Our ref: SSD-65924461

Subject: Request for Additional Information – Stephen Road Multi-level Warehouse,
Banksmeadow (SSD-65924461)

Attachment 1: The Department's comments on the Submissions Report

Appendix B Operational Noise Contours

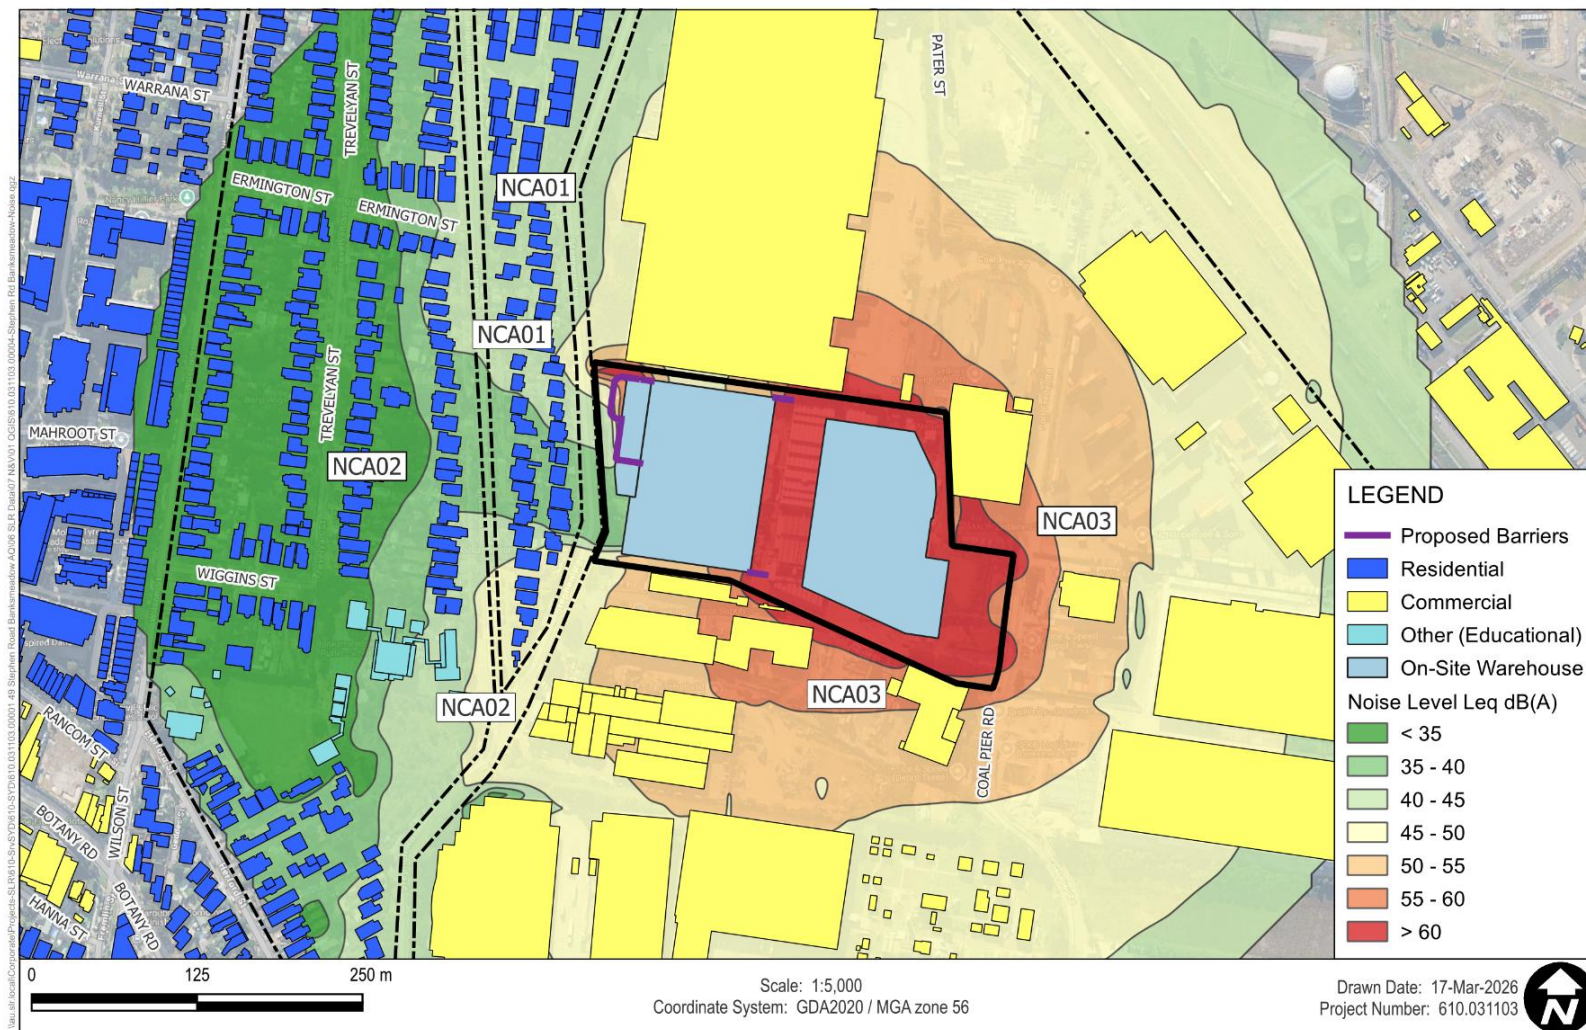
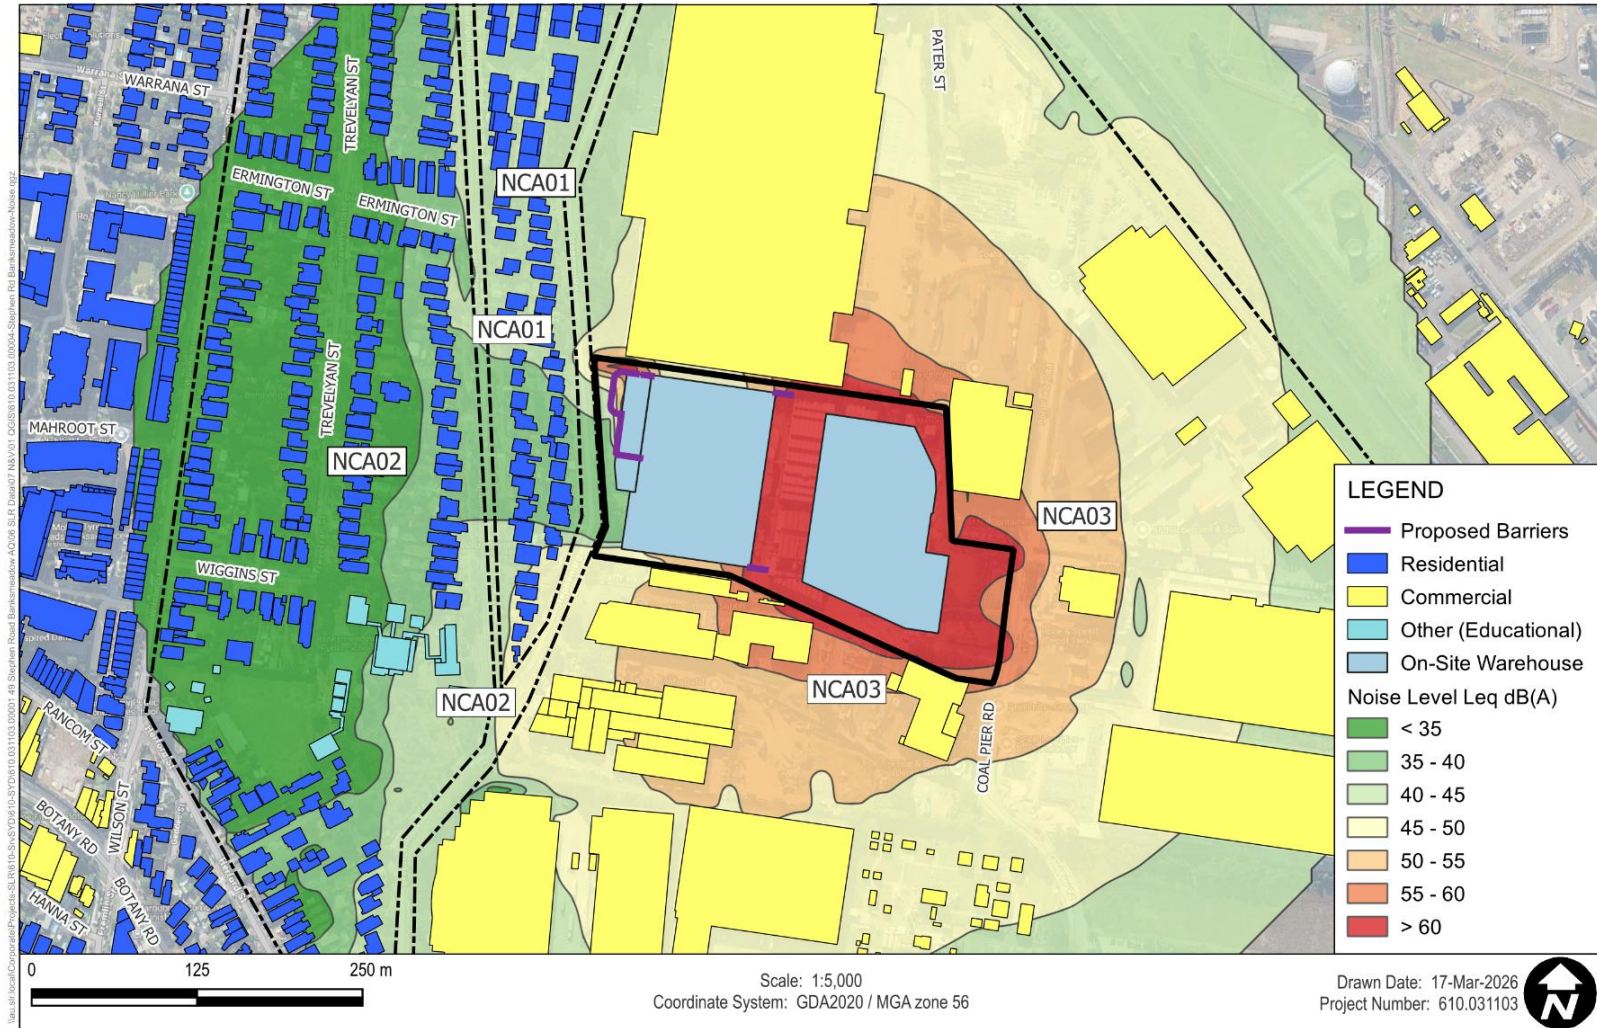
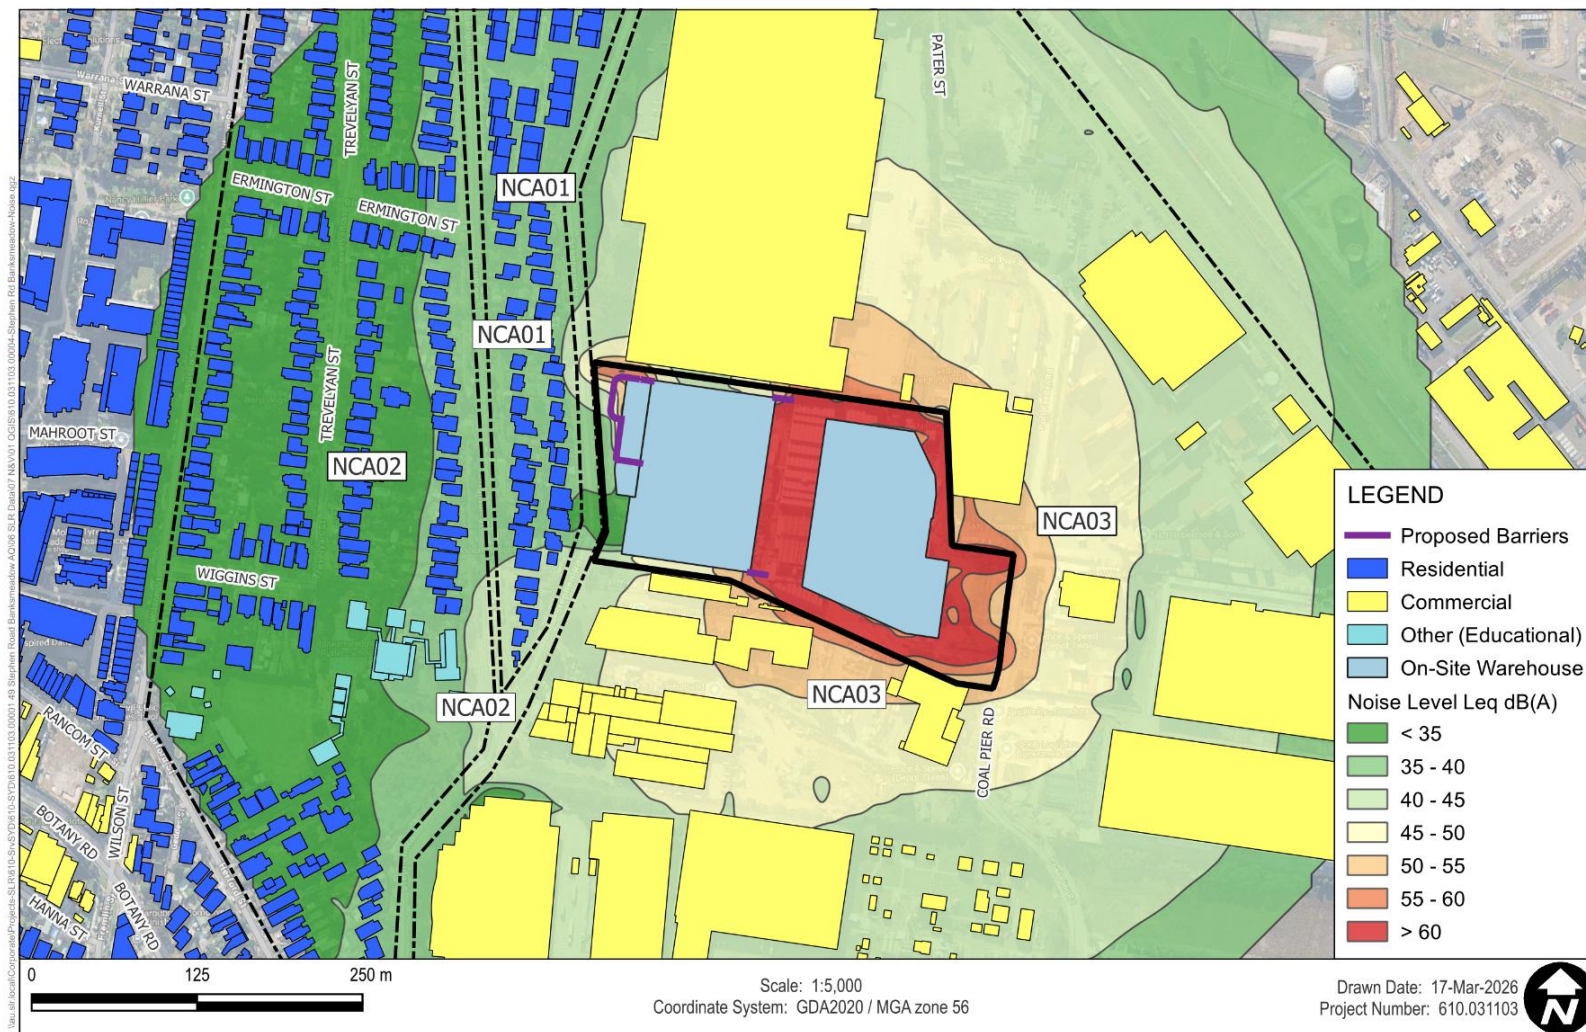
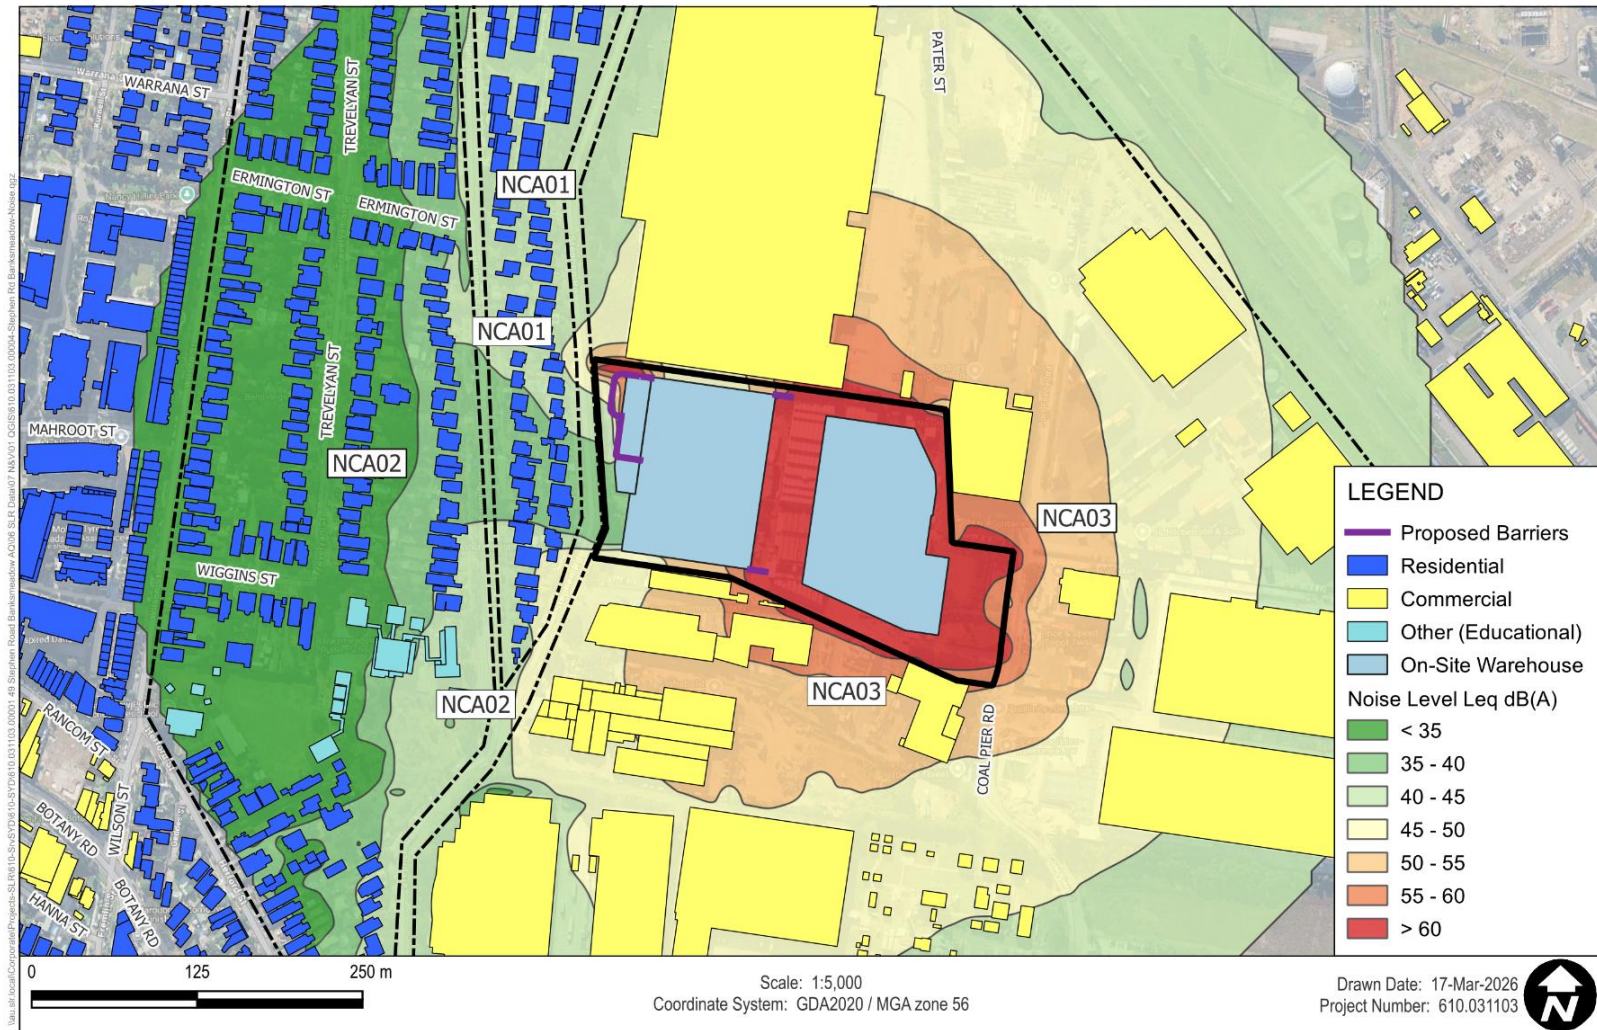
3. The noise contour maps provided in Appendix B of the NVIA appear unchanged from the previous assessment and do not appear to reflect the reduction in predicted noise levels at receiver NCA02 outlined above. Please review this apparent inconsistency and provide clarification regarding the discrepancy.
